## Validation Checklist

Lodgement Number : **LDG-067710-23**  
Case Number: **ABP-318268-23**  
Customer: **Mary Lou McDonald TD**  
Lodgement Date: **18/10/2023 13:51:00**  
Validation Officer: **Dáire Littleton Caden**  
PA Name: **Dublin City Council North**  
PA Reg Ref: **5432/22**  
Case Type: **Normal Planning Appeal PDA2000**  
Lodgement Type: **Appeal**

Re. Appeal against the decision of Dublin City Council to grant planning permission for development at No. 61 O'Connell Street Upper (a Protected Structure), including the rear onto Henry Place, Dublin 1. DCC Reg. Ref. 5432/22

Fig. 54
Illustrative drawings of No.61 Upper O'Connell Street.
Note: Drawings are not to scale. The drawings within this report are for illustrative purposes only. Please refer to detailed drawings submitted with the application for accurate dimensions and information.

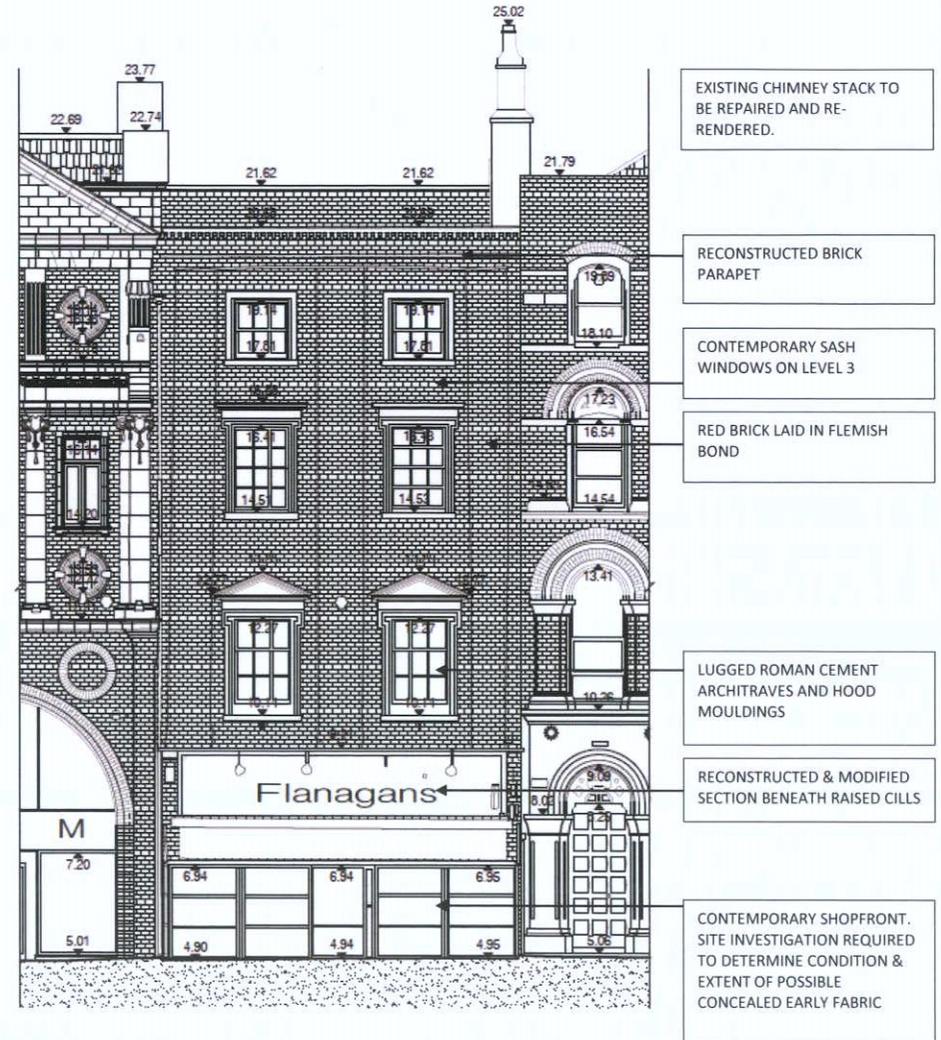
I particularly question the creation of the new access to be constructed through the Protected Structure at No. 61 O'Connell Street Upper (see above in green). The developer has already proposed a new street and plaza elsewhere and the creation of an arched passageway through this Protected Structure is unnecessary. It will also be difficult to manage as there will be gateway access into the new passageway.

Dublin City Council's own Record of Protected Structures (RPS) is intended to protect the front façade in total. DCC has ignored its own RPS and permitted a new passageway to be punched through this Protected Structure. I ask the ABP to refuse permission for this unnecessary development.

The current Development Plan refers to all of the front façade of No. 61 as being a Protected Structure. Yet the applicant wants to punch an unnecessary arched gated route through that front façade. It seems pointless for DCC to have recently revised the Protected Structure listing to include the front façade in total and to then permit this proposed development.
